Reference No:	<b>2025/62/92710/E</b>
Site Address:	69, Ravenshouse Road, Scout Hill, Dewsbury, WF13 3QW
Description:	Erection of first floor rear extension
Recommending Officer:	Faiza Bano

**DECISION – CONDITIONAL FULL PERMISSION**

## **OFFICER REPORT**

PROPOSED REAR ELEVATION
(south West)

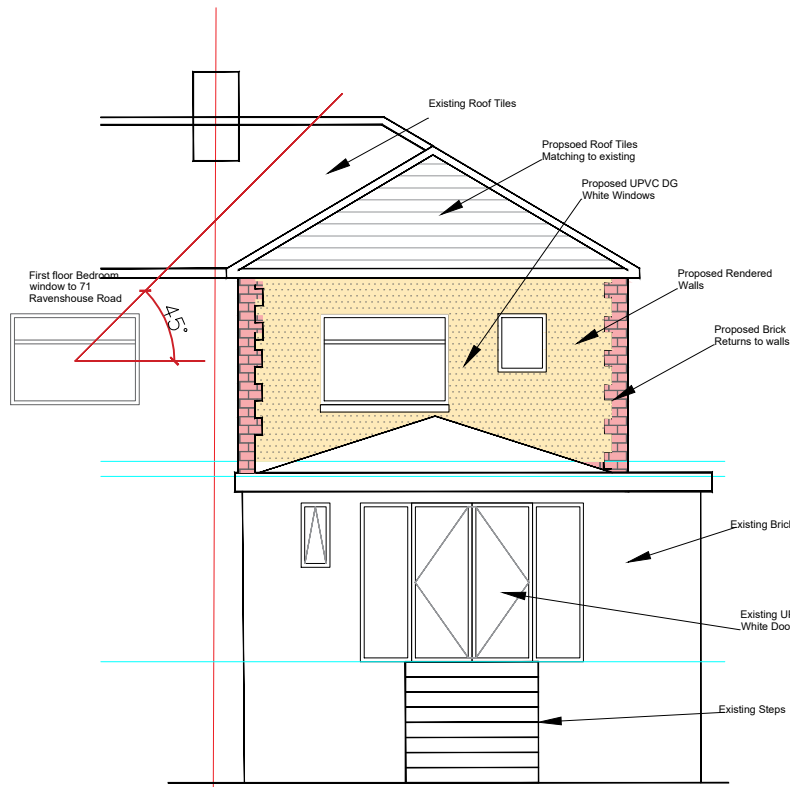
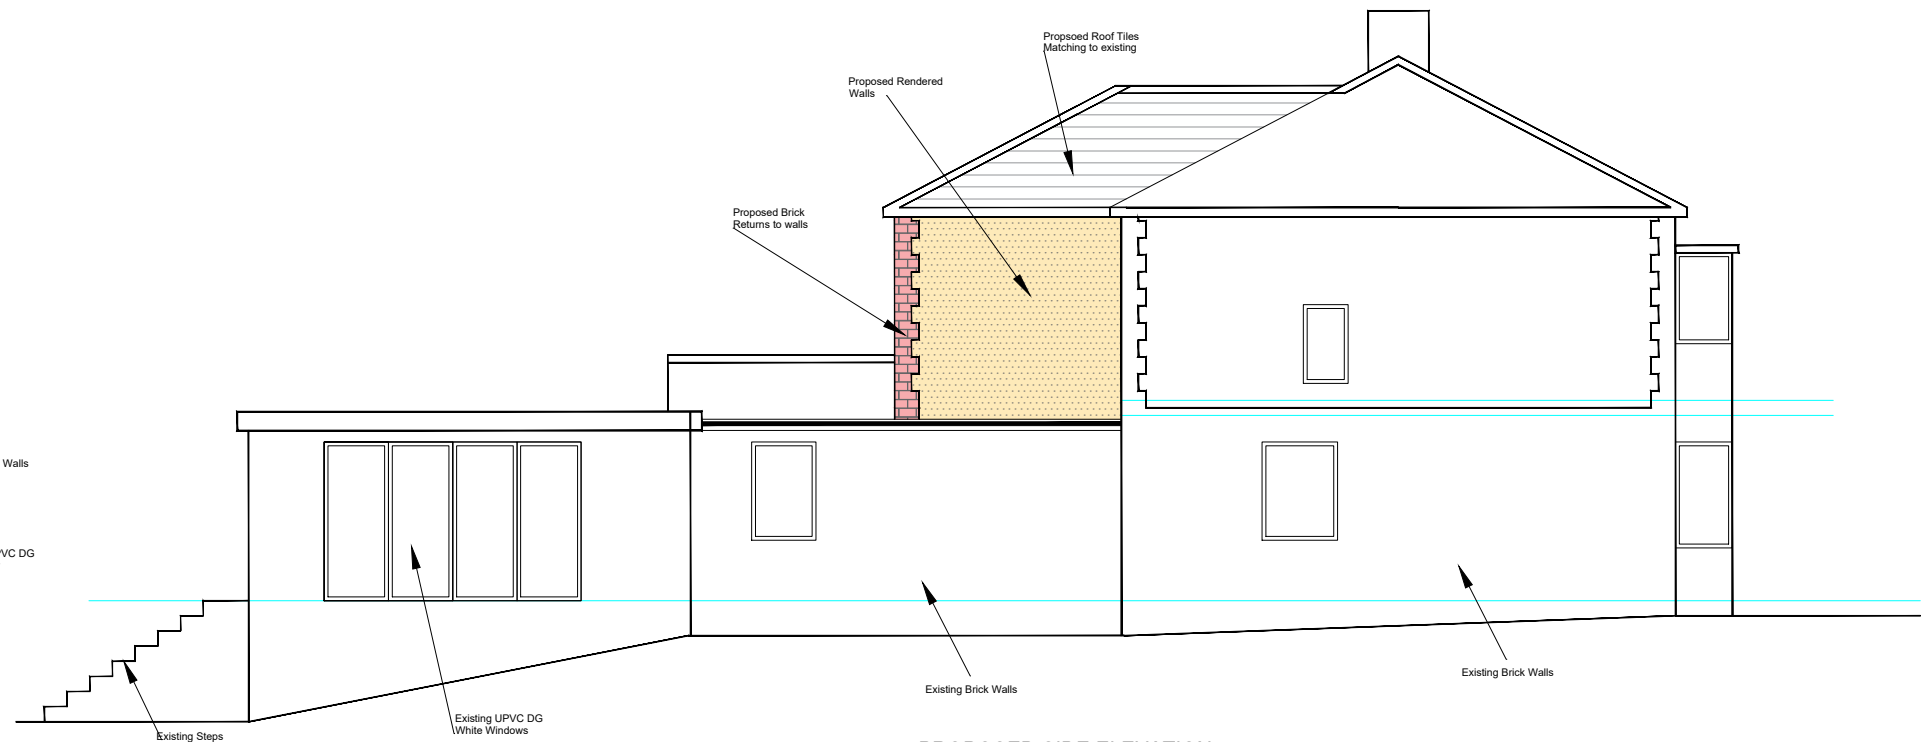
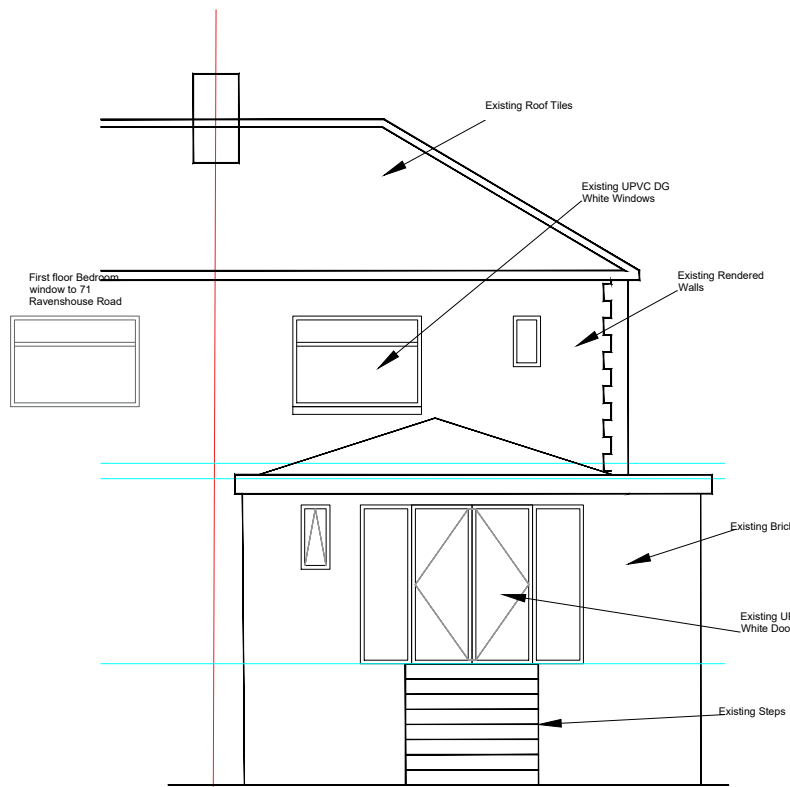
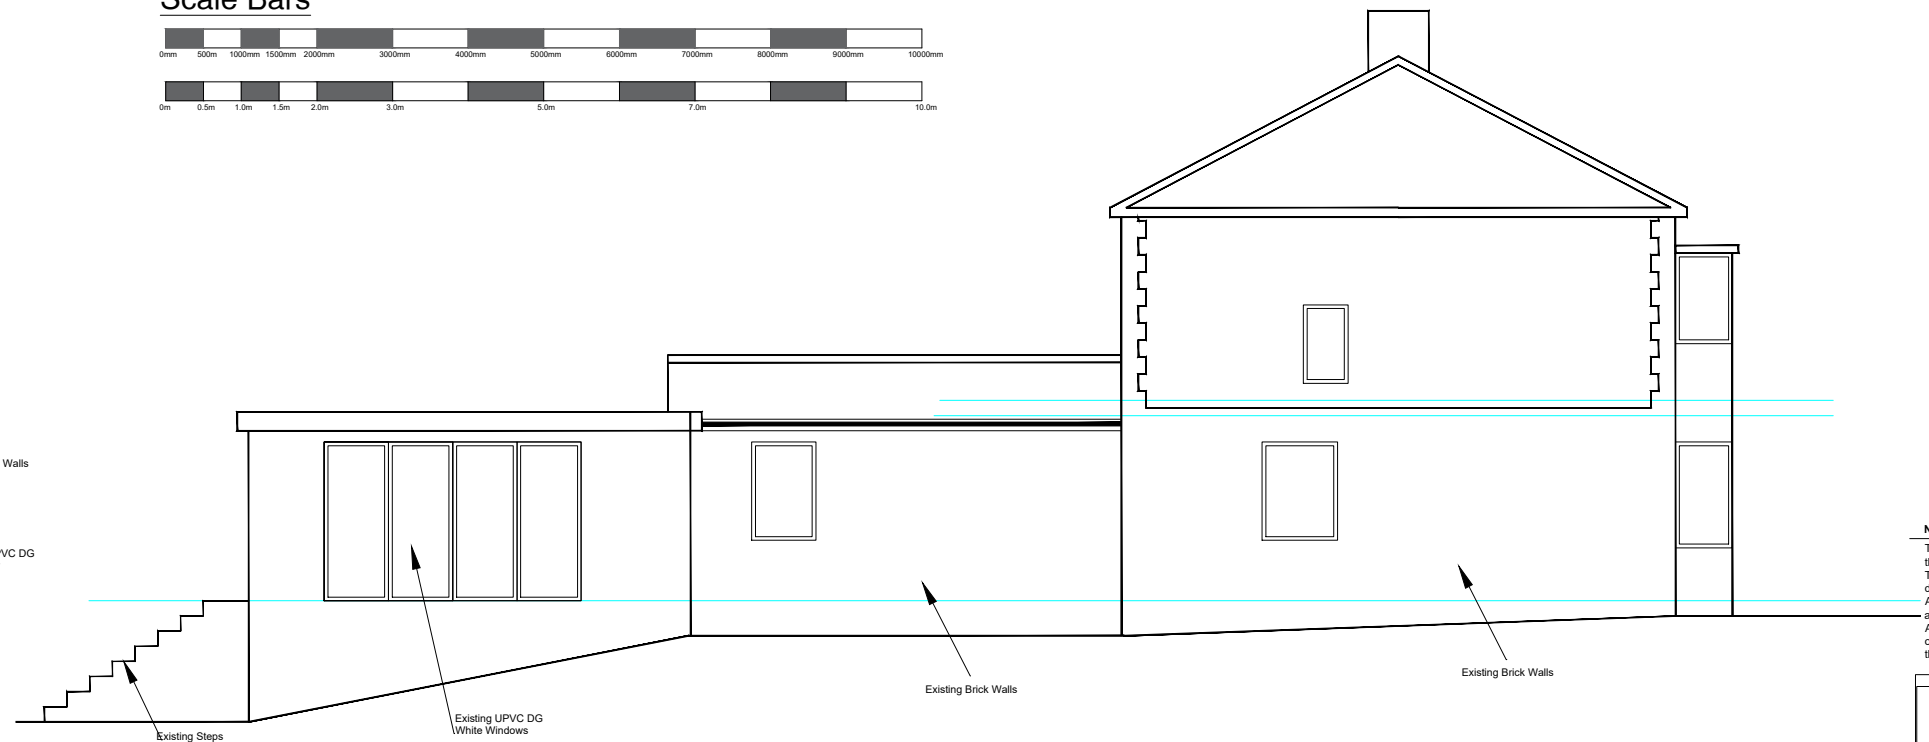
Amended plans were submitted proposing to extend the width of the extension across the full width of the dwelling, including the portion adjacent to the shared boundary with the adjoining property. Further amended plans were requested in order to illustrate the 45-degree impact in an elevational view. The scheme has been assessed accordingly.

It is acknowledged that the proposed extension would project past the first floor window serving the neighbouring property. When a line of 45 degrees is drawn from the centre of the window towards the proposed development, in plan view, the proposal would marginally infringe this guideline. However, when the 45 degree test is applied in elevation, the extension remains outside the guideline and therefore complies with this aspect of the assessment.

BRE guidance within the Site Layout Planning for Daylight and Sunlight recognises that where development lies within 90 degrees due south of a neighbouring window, the elevation test provides an additional indicator of potential daylight impact. In this instance, while the proposed extension would lie broadly within due south, it would only marginally infringe the 45 degree

line in plan view and demonstrates compliance with the 45 degree line in elevation due to the pitched roof. While it is acknowledged there would be some loss of daylight/sunlight, on the basis of the above, it is not considered that the development would have a detrimental impact on daylight/sunlight provisions to this property.

While some additional massing would be introduced at first-floor level due to the increased width of the extension, the 45-degree assessment indicates that this would not give rise to harmful overbearing effects. Any existing impacts experienced at ground-floor level primarily arise from the established single-storey projection, and the revised first-floor addition is not considered to materially worsen this relationship.

PROPOSED FIRST FLOOR PLAN

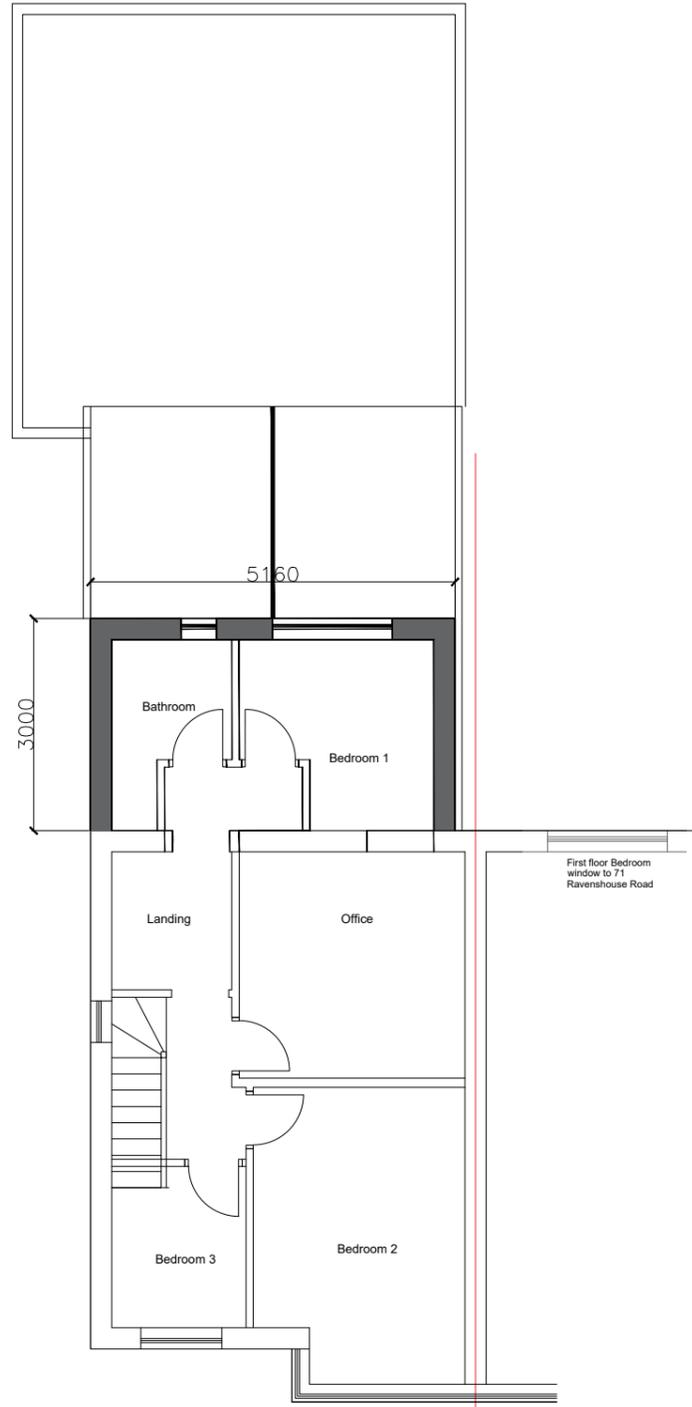
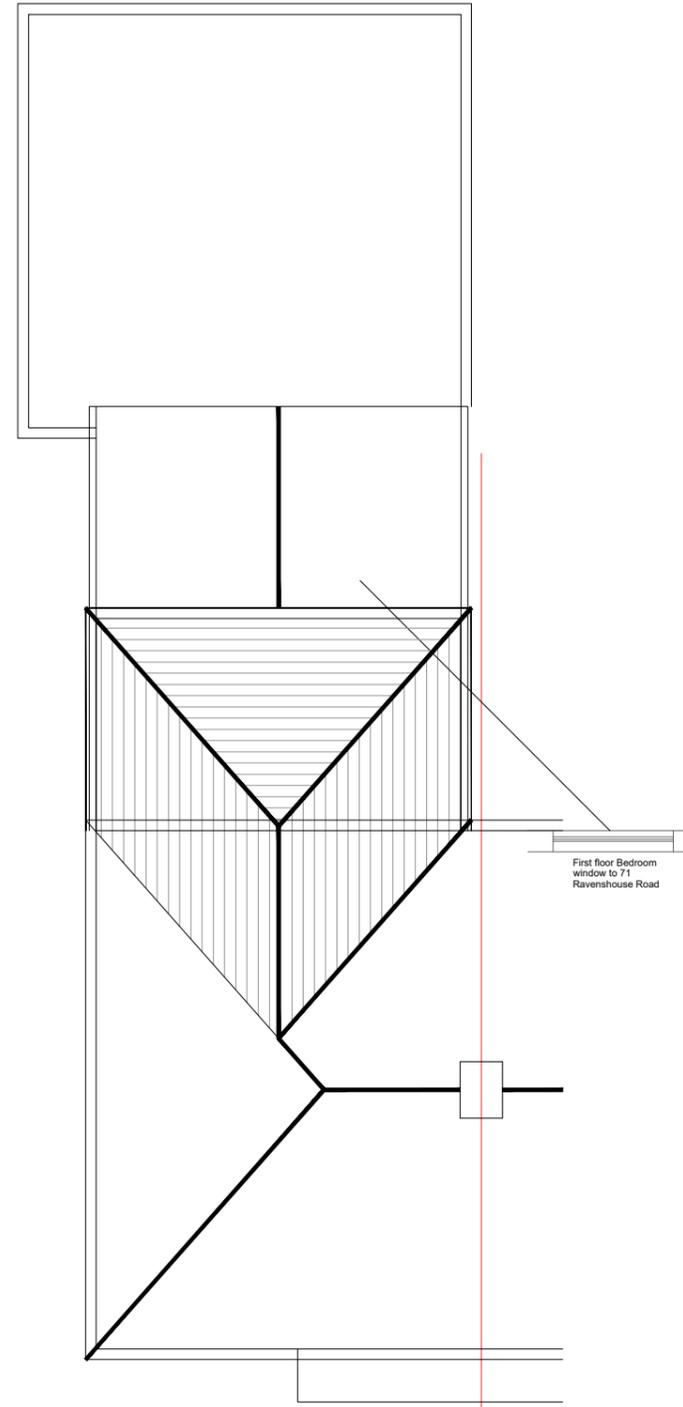
The proposed extension would be set in 1.2 metres from the shared boundary with the adjoining property, with a rearward projection of 3 metres and an overall width of 4.2 metres. The roof form would comprise a pitched roof set perpendicular to the main ridgeline.
